City of Portland, Maine - Building or Use Permit Application
 389 Congress Street, 04101 Tel: (207) 874-8703, Fax: (207) 874-8716

Permit No: 06-1424	Issue Date:	CBL: 406 F056001
------------------------------	--------------------	----------------------------

Location of Construction: 29 STEPPING STONE LN #6	Owner Name: KING CONSTRUCTION CORP	Owner Address: 198 SACO AVE	Phone:
Business Name:	Contractor Name: King Construction Corp	Contractor Address: 198 Saco OOB	Phone 2079347622
Lessee/Buyer's Name	Phone:	Permit Type: Single Family	Zone:

Past Use: Vacant Land	Proposed Use: Single Family Home/ New Single Family Home- w/ 2 Car garage	Permit Fee: \$1,515.00	Cost of Work: \$142,000.00	CEO District: 4
		FIRE DEPT: <input type="checkbox"/> Approved <input type="checkbox"/> Denied	INSPECTION: Use Group: Type

LOT 6 - GRADING PLAN
AUTUMN GLEN SUBDIVISION

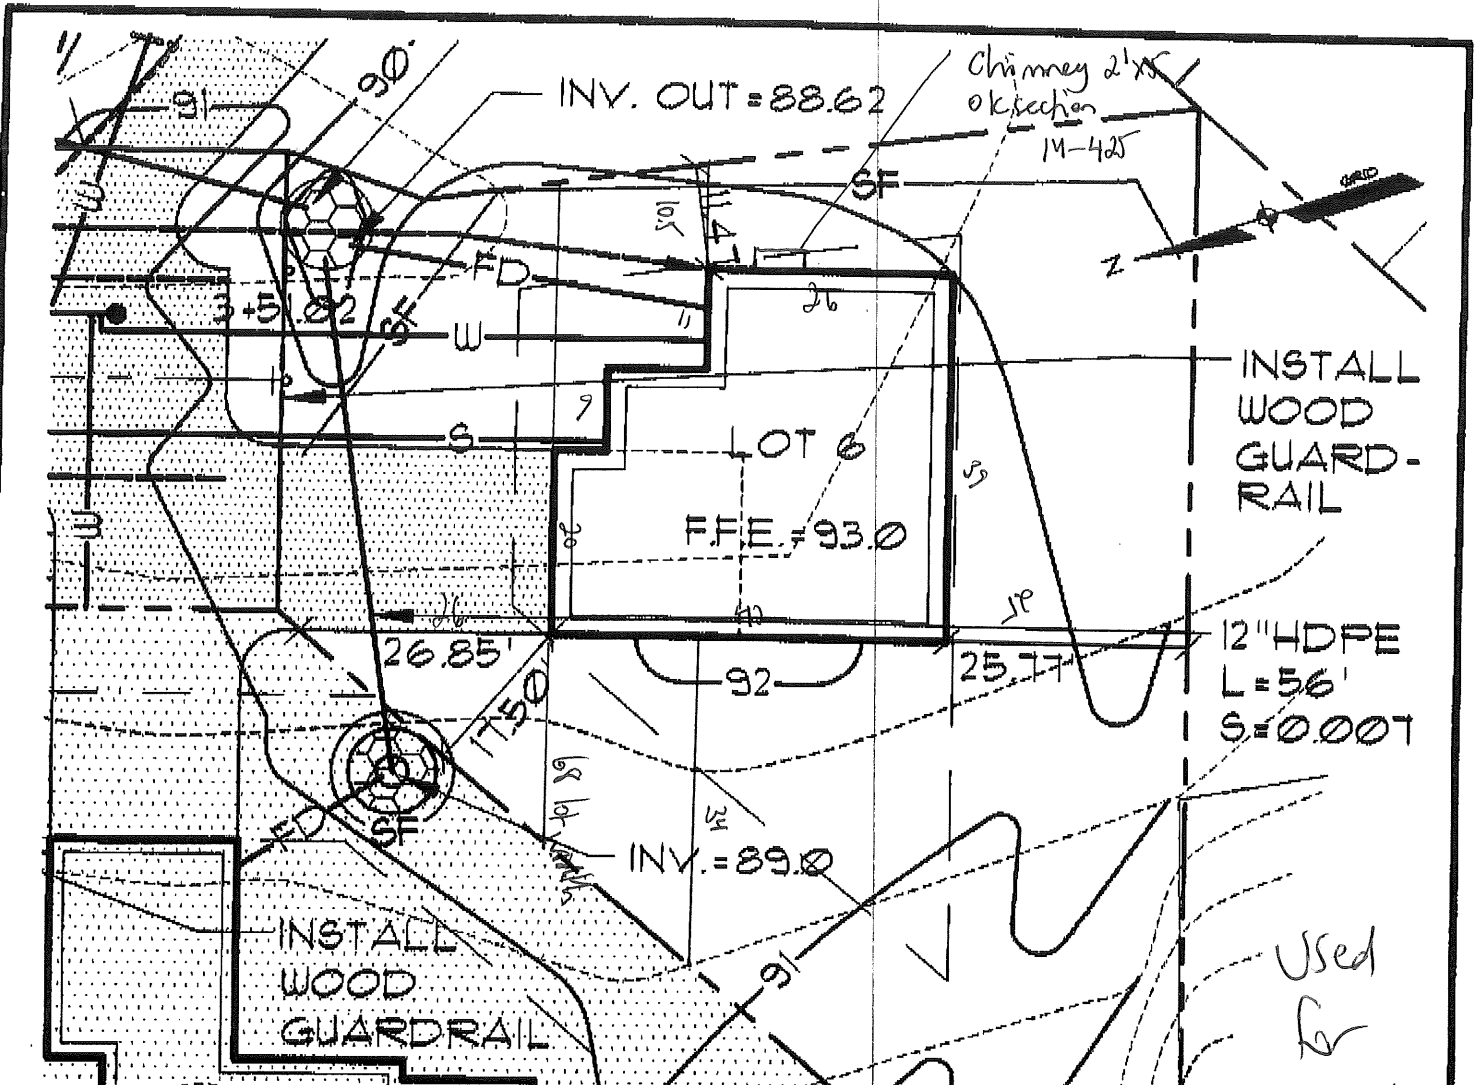
10/4/2006-amachado: Left message for King Weinstein to call me. Front setback is not met. Scales at 24.5' not the required 25' and the elevationn plans show a daylight basement in the back, but the grading plan does not match this.

10/6/2006-amachado: Received revised site plan. Meets zoning requirements. Still waiting for correct elevation plans.

ROOF FRAMING PLAN

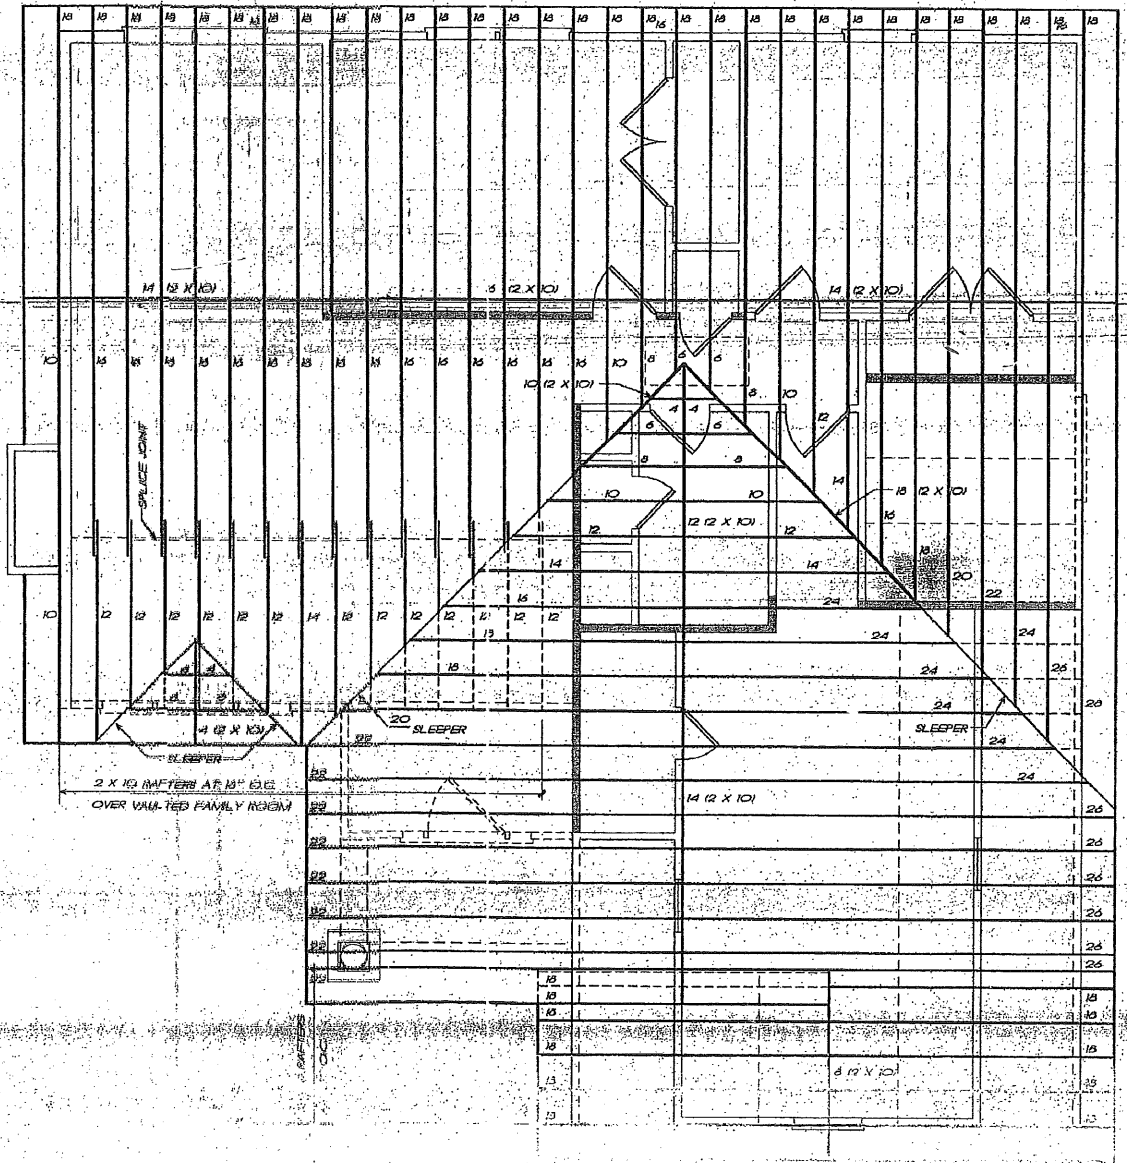
- 9) As discussed, the rafters must be 2" x 10"s.
